CITY OF COLORADO SPRINGS EROSION CONTROL PLAN REVIEW
 This grading plan is filed in accordance with section 7.7.1503 (enacted as ord. 82-56) of the code of the City of Colorado Springs, 2001, as amended. Erosion control is reviewed in accordance with the Drainage Criteria Manual, Vol. I (2014) and Vol. II (2014); latest revisions.

TITLE PAGE
EROSION AND STORMWATER QUALITY CONTROL PLAN

Clear Springs Ranch
Access Road Fire Break

Markup Summary

**TITLE PAGE**  
**EROSION AND STORMWATER QUALITY CONTROL PLAN**

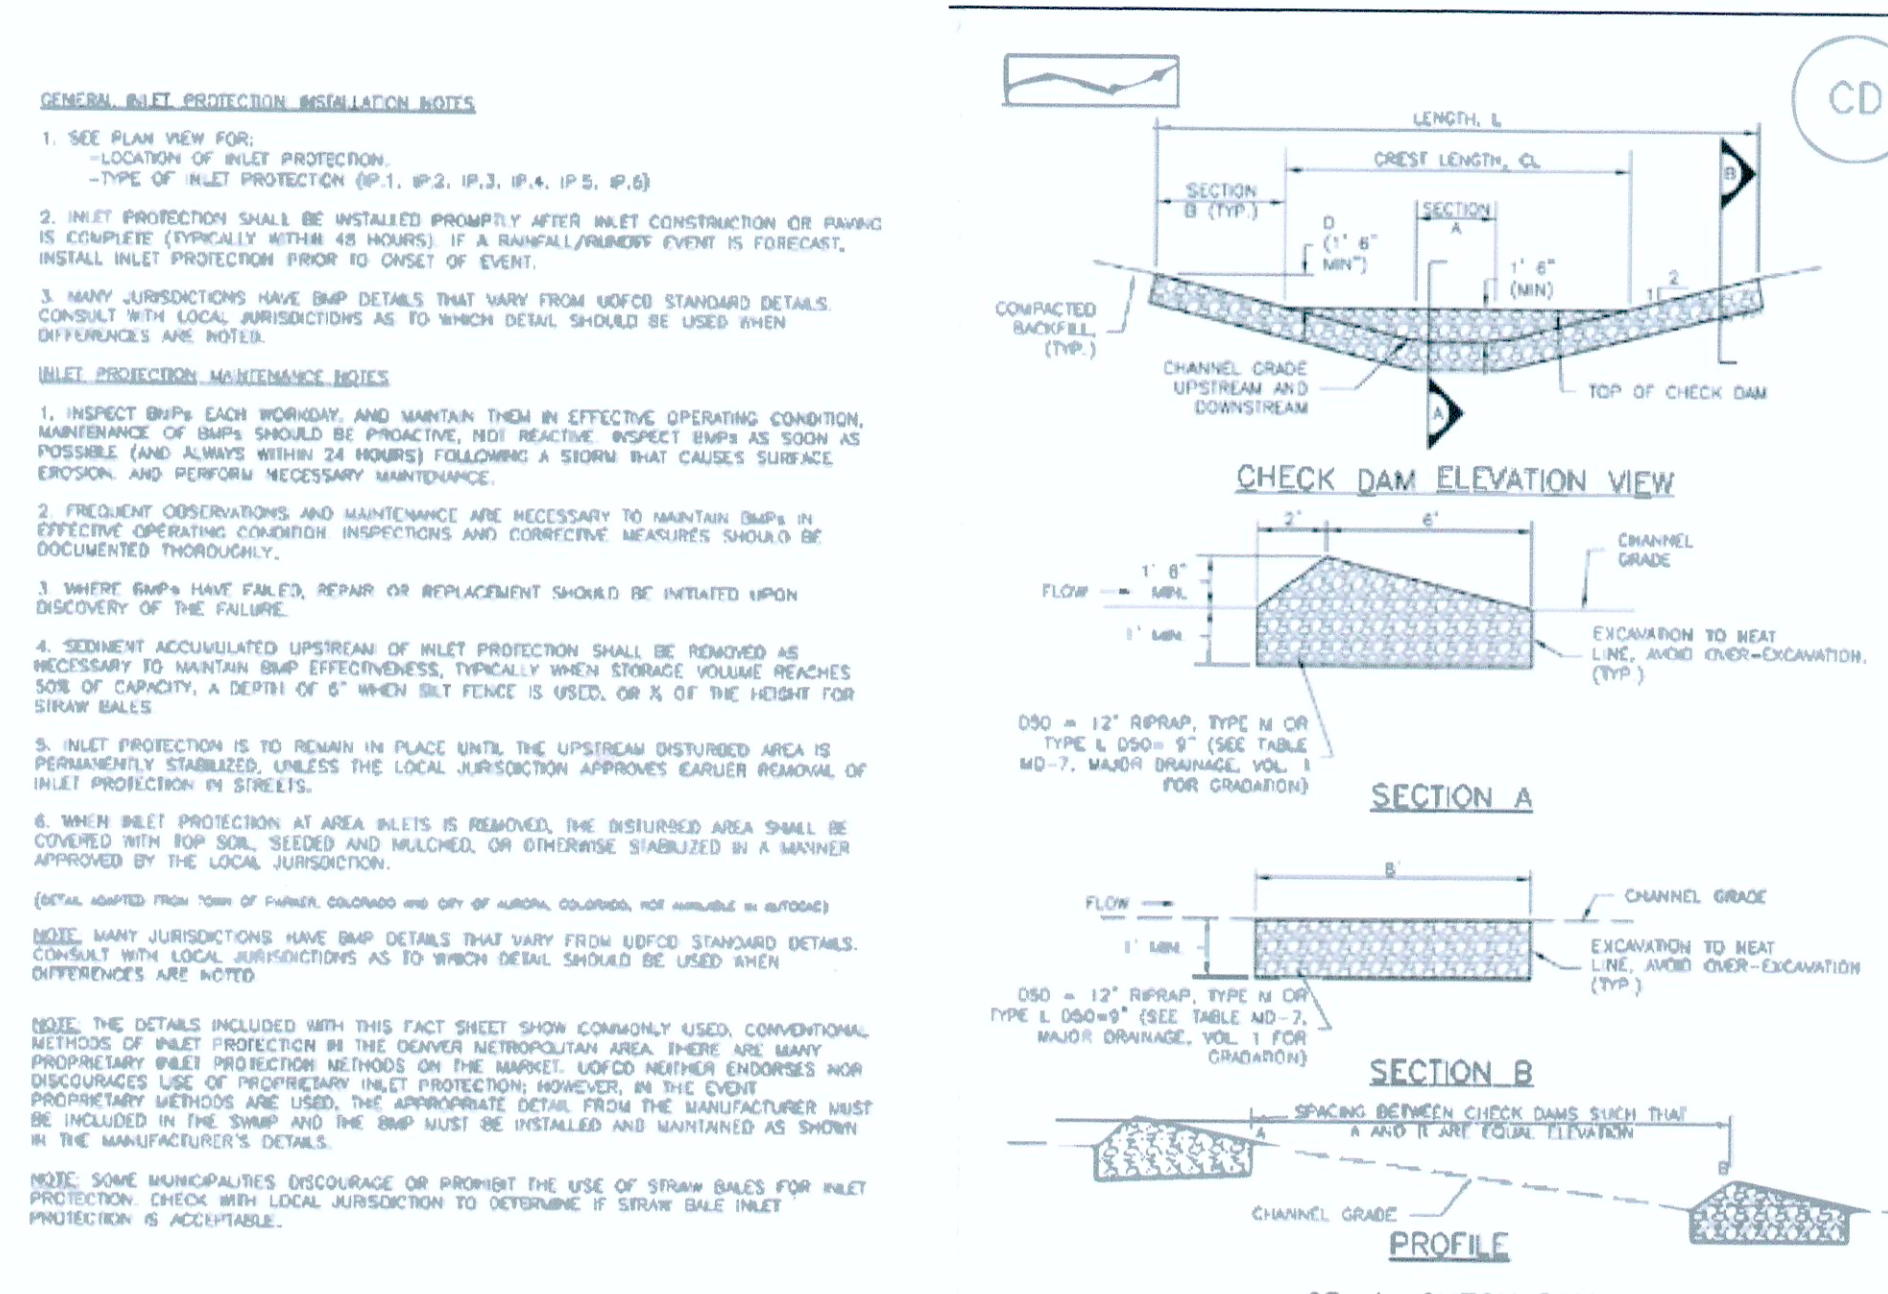
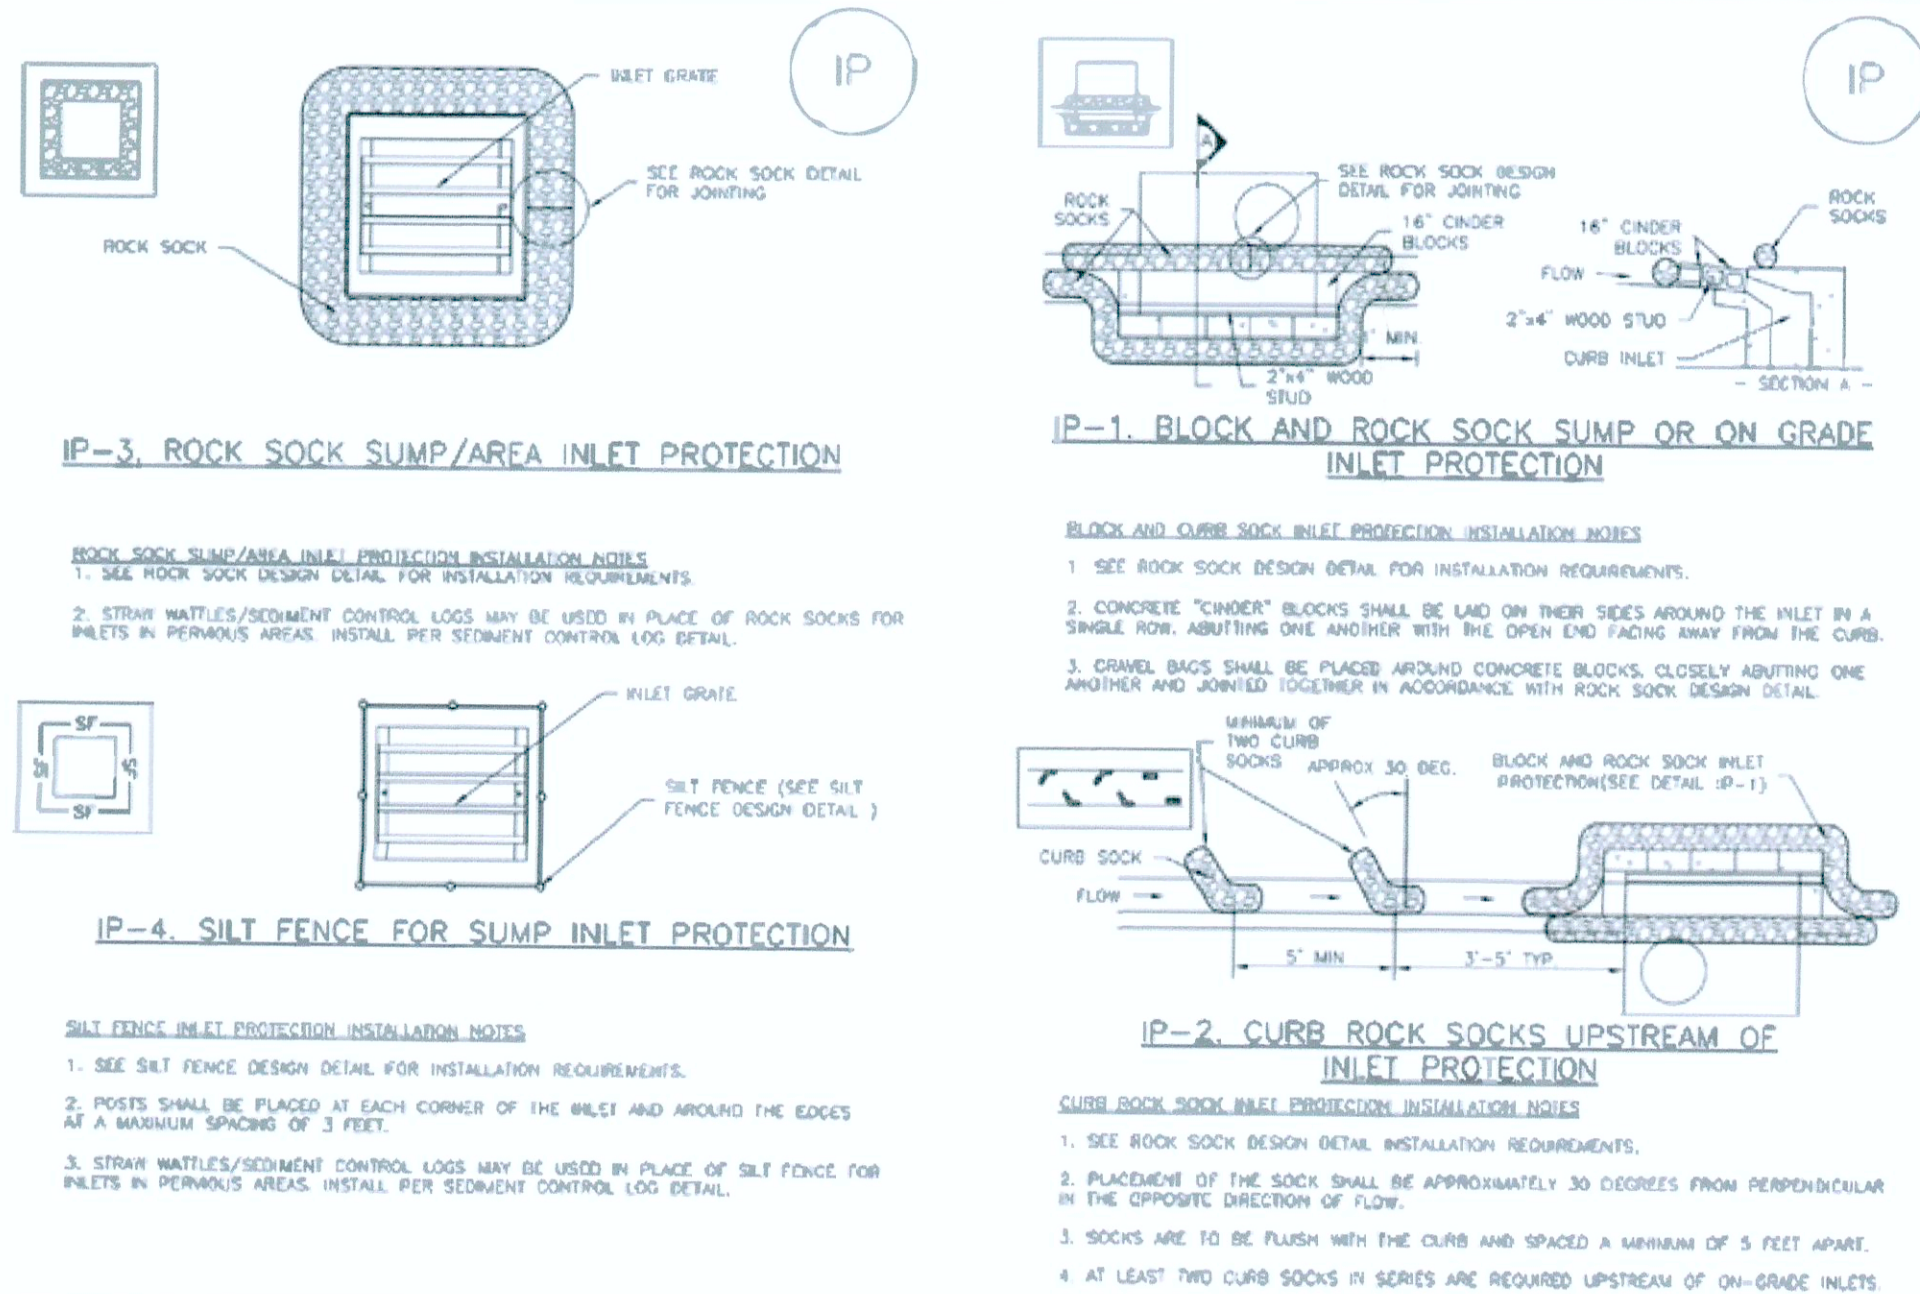
Clarify where this is located. Show this on sheet 4.

State that all disturbed areas not within the proposed roadway must be reseeded.

**Figure  
Number**  
**3**

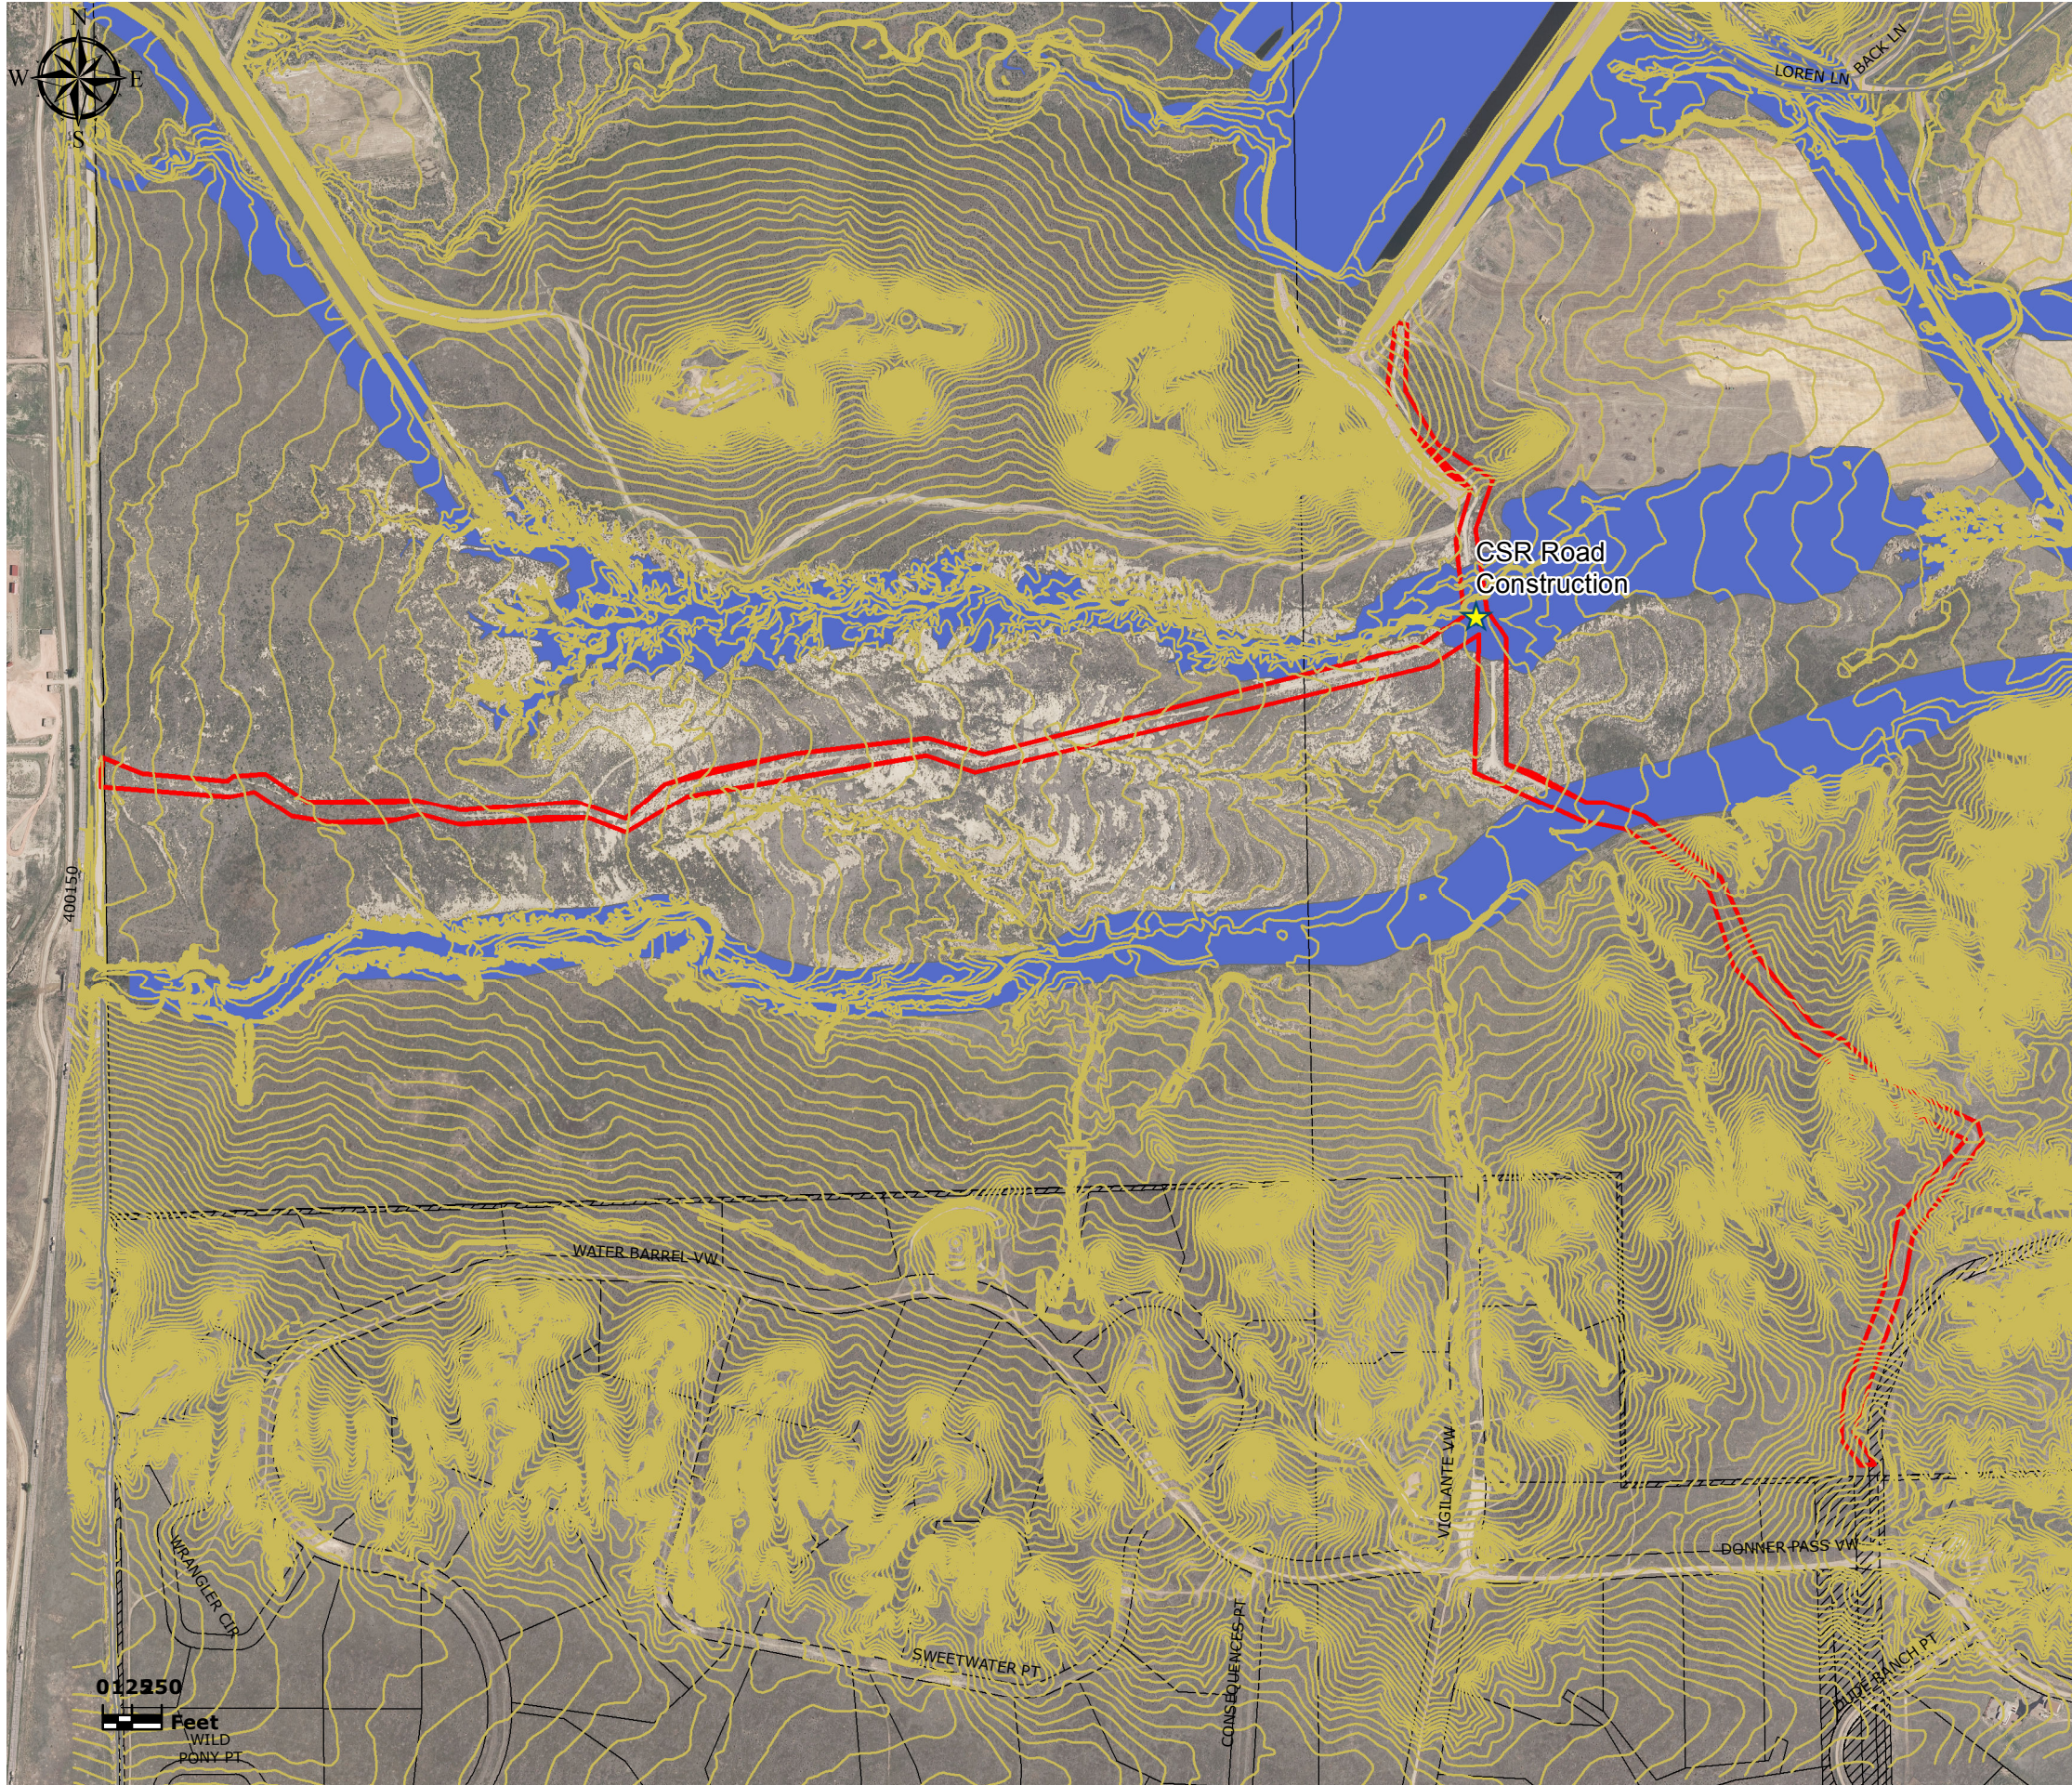
Please identify if any disturbance is anticipated in the floodplain area. Approval from the appropriate local and federal jurisdictions will be required.

Separate the existing and proposed contours into two line types

Please call out the owner of each parcel the road runs through.
